**DPIE REQUEST FOR ADVICE – HUNTLEE STAGE 2 – SSD-70748466**

I refer to your request via the NSW Major Projects Planning Portal for advice from Singleton Council on the Environmental Impact Statement and accompanying information for Huntlee Stage 2 - SSD-70748466. Council notes that the due date for submissions was the 19 August 2024.

HUNTLEE STAGE 2 DA VILLAGE 2
CENTRAL & SOUTH DETAILED
SUBDIVISION PLAN (8)

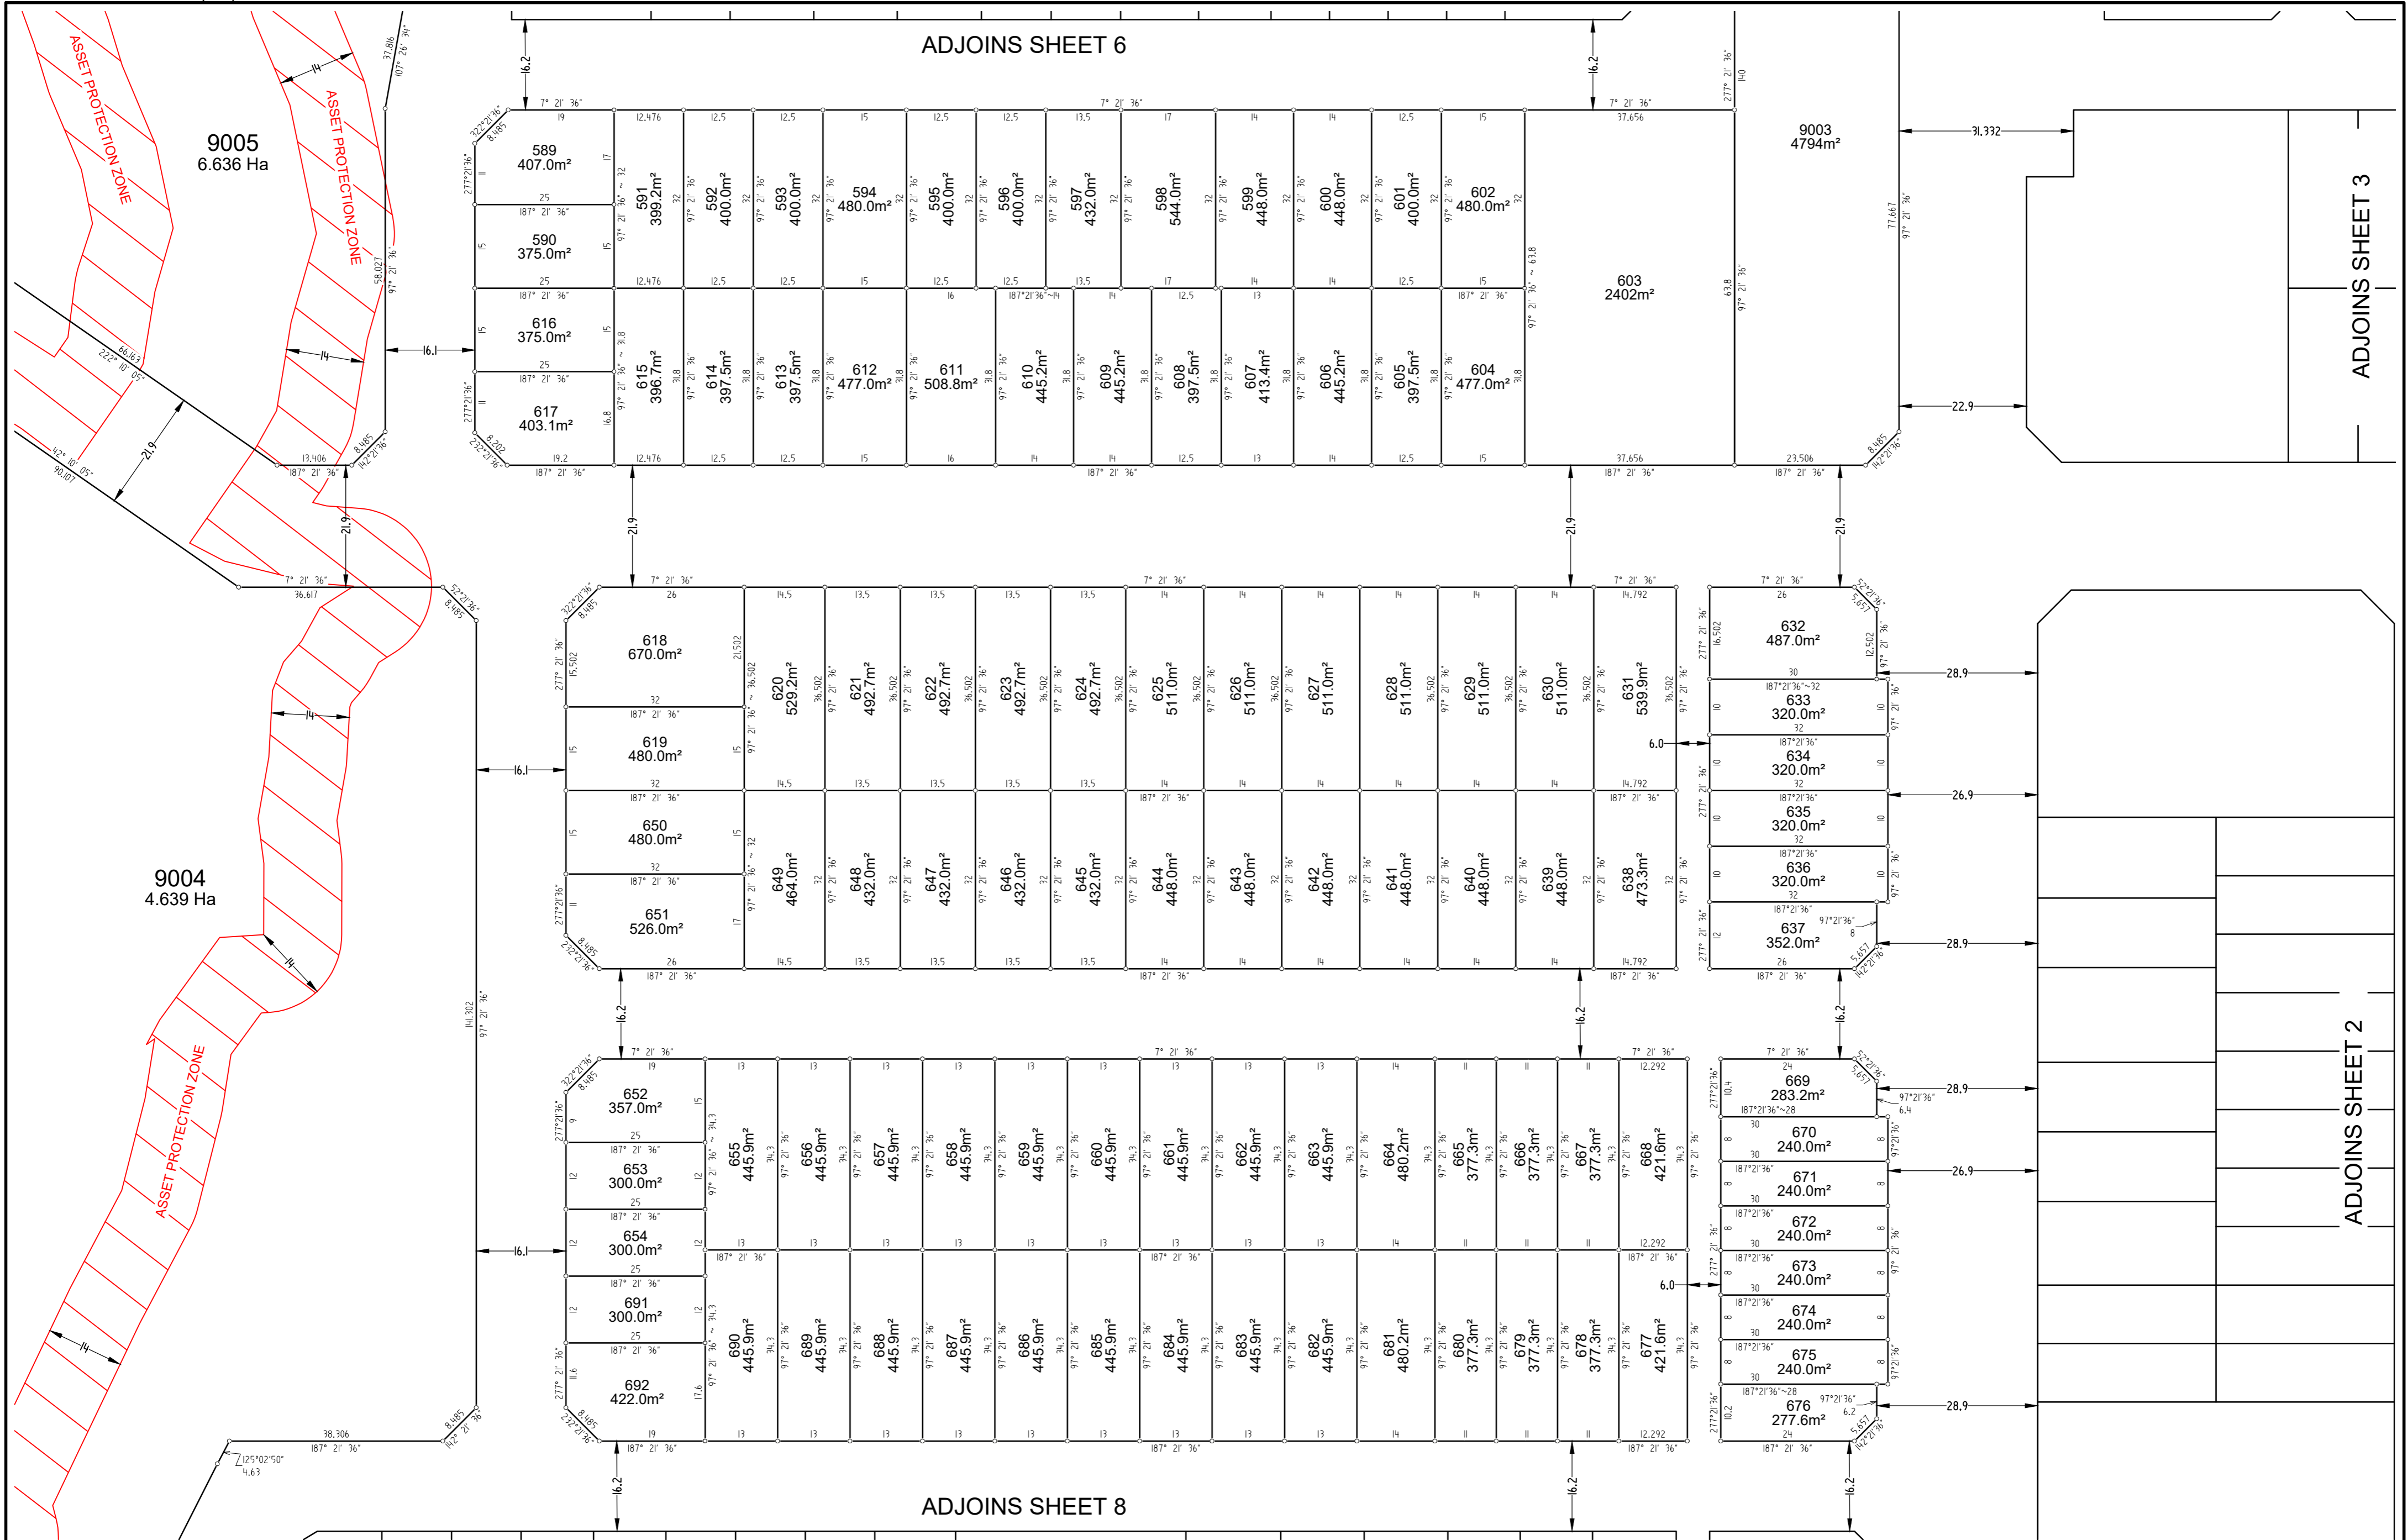
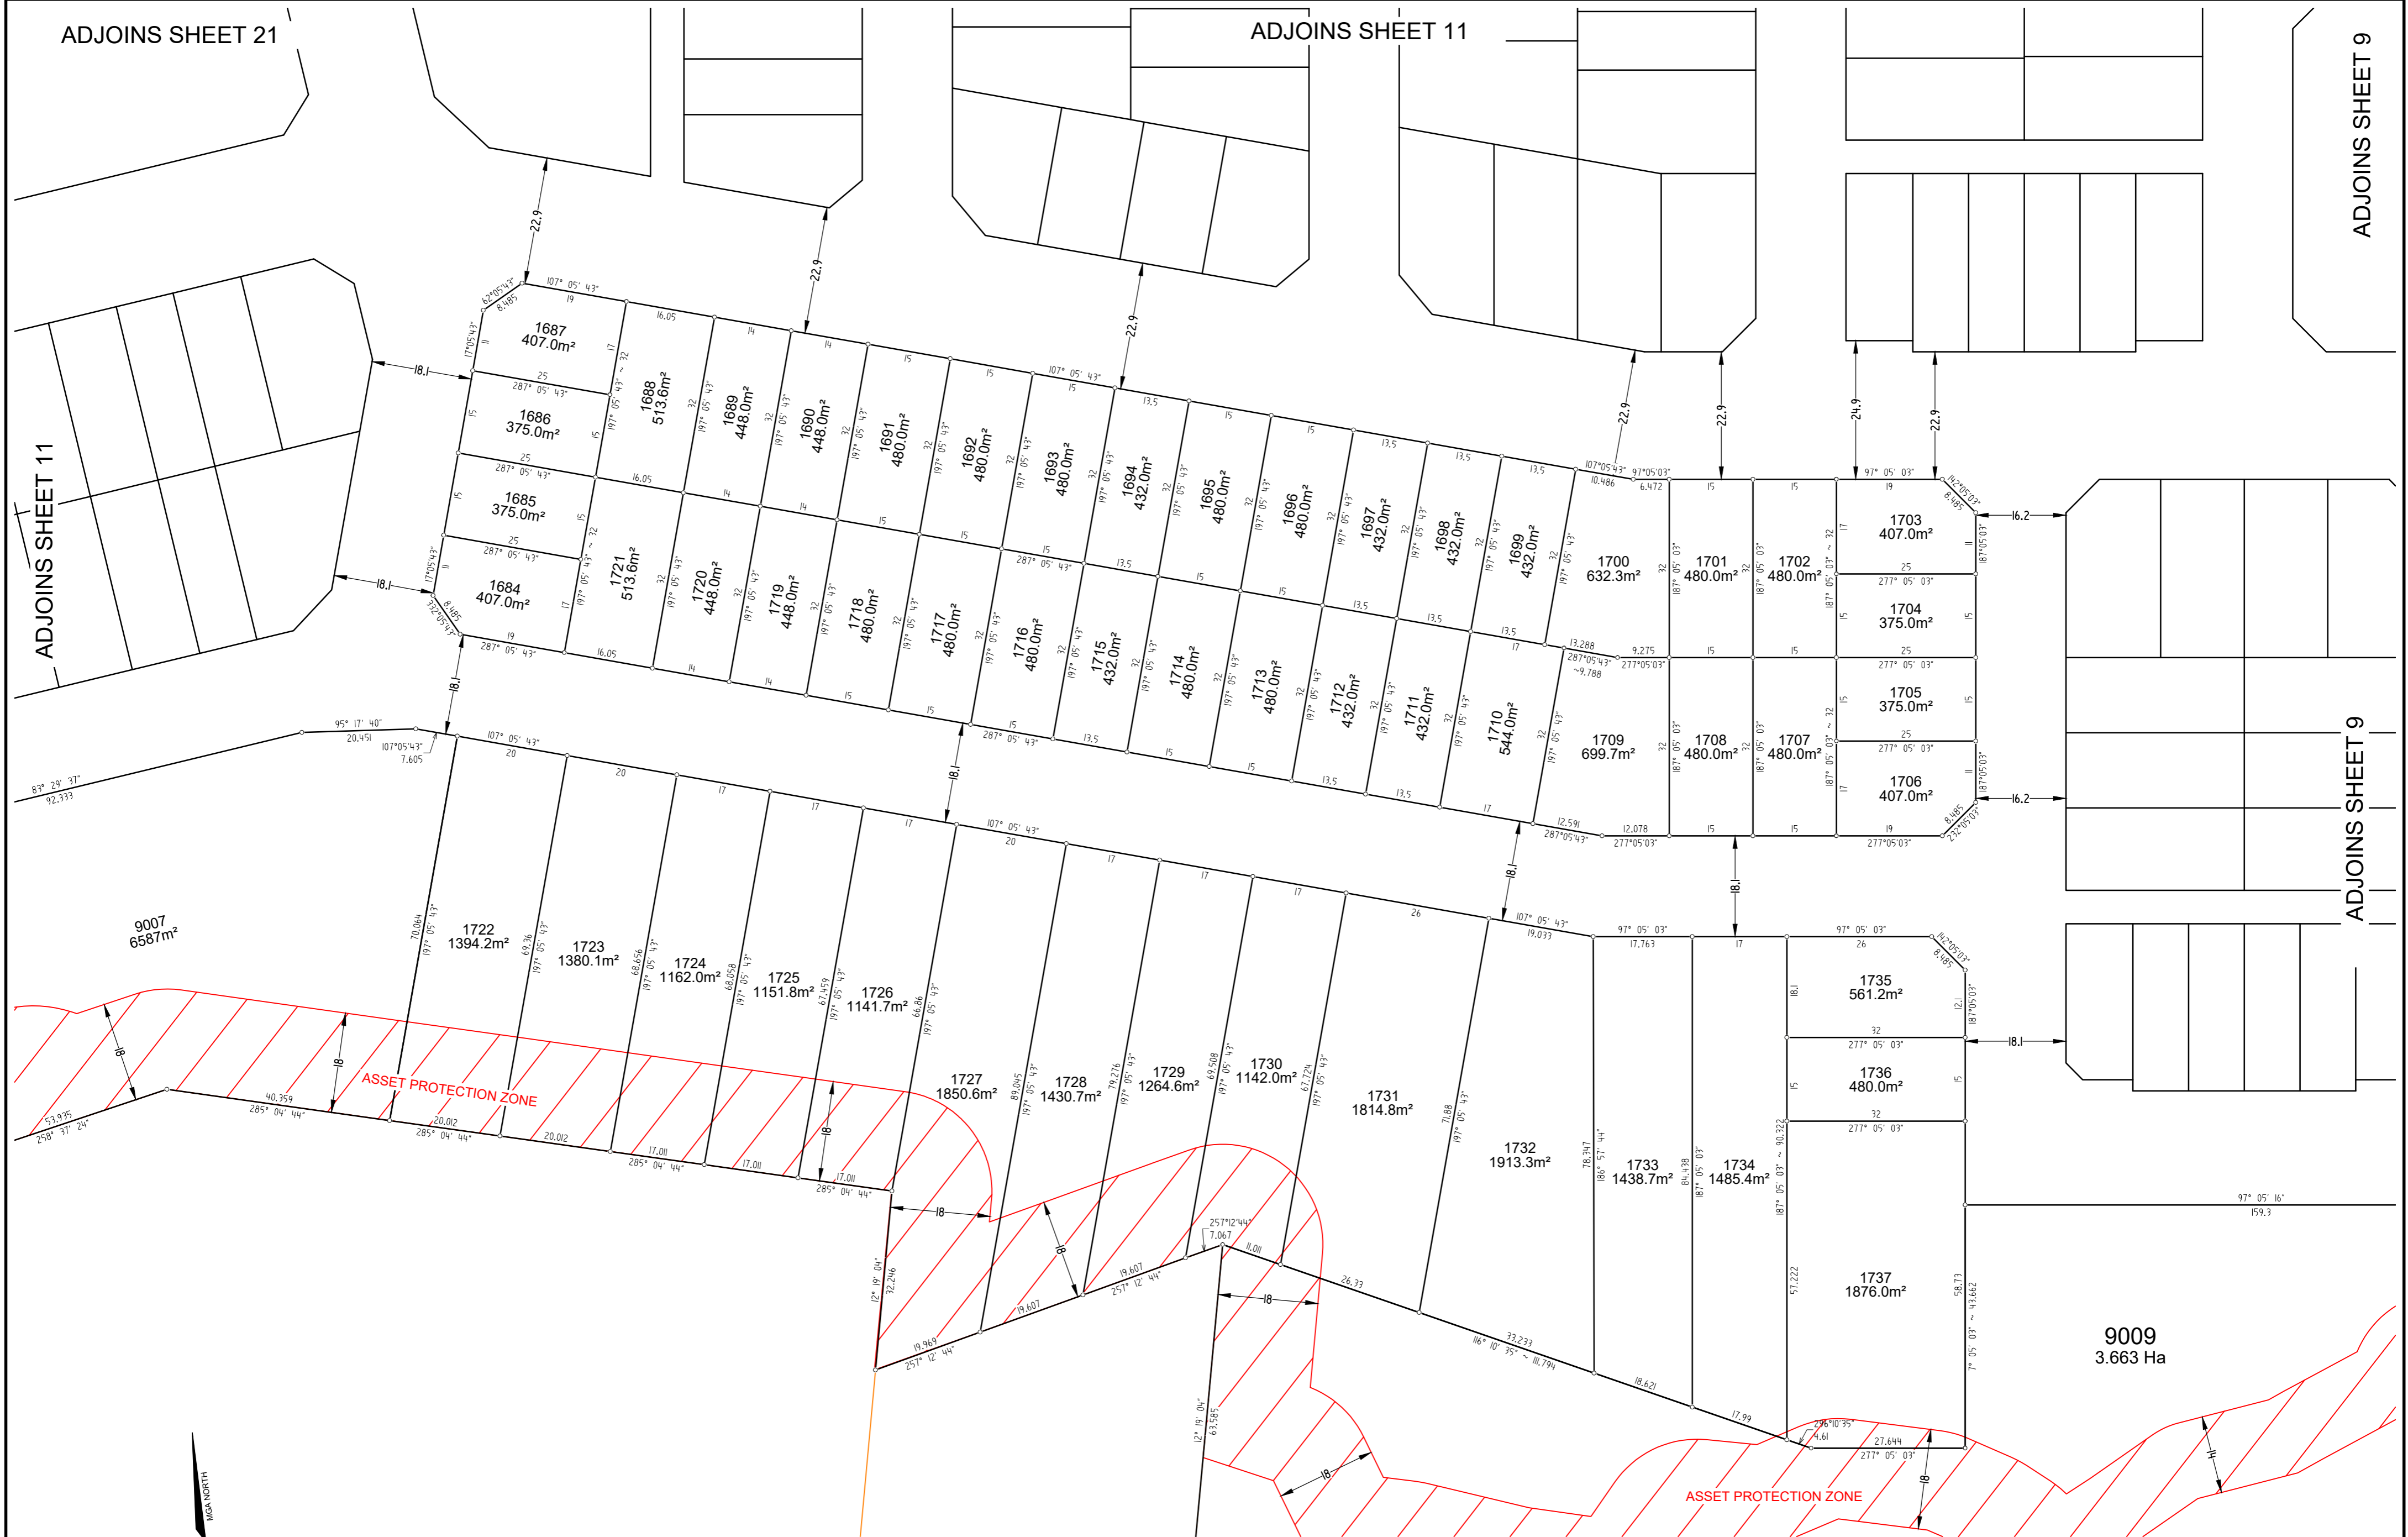
The detailed subdivision plan for Village 2 shows that the Developer is indicating that the proposal will meet targets regarding supplying a range of lot sizes to enable diverse housing. Further detail on the controls that will apply to prevent these larger lots from being further subdivided through modifications. For example, there are approximately 20 medium density lots in Village 2 Centre and South, and it is unclear what controls are in place to stop these being further subdivided into the smaller Cottage lots by either the Developer or future owners of the lot, noting this has happened in Stage 1.
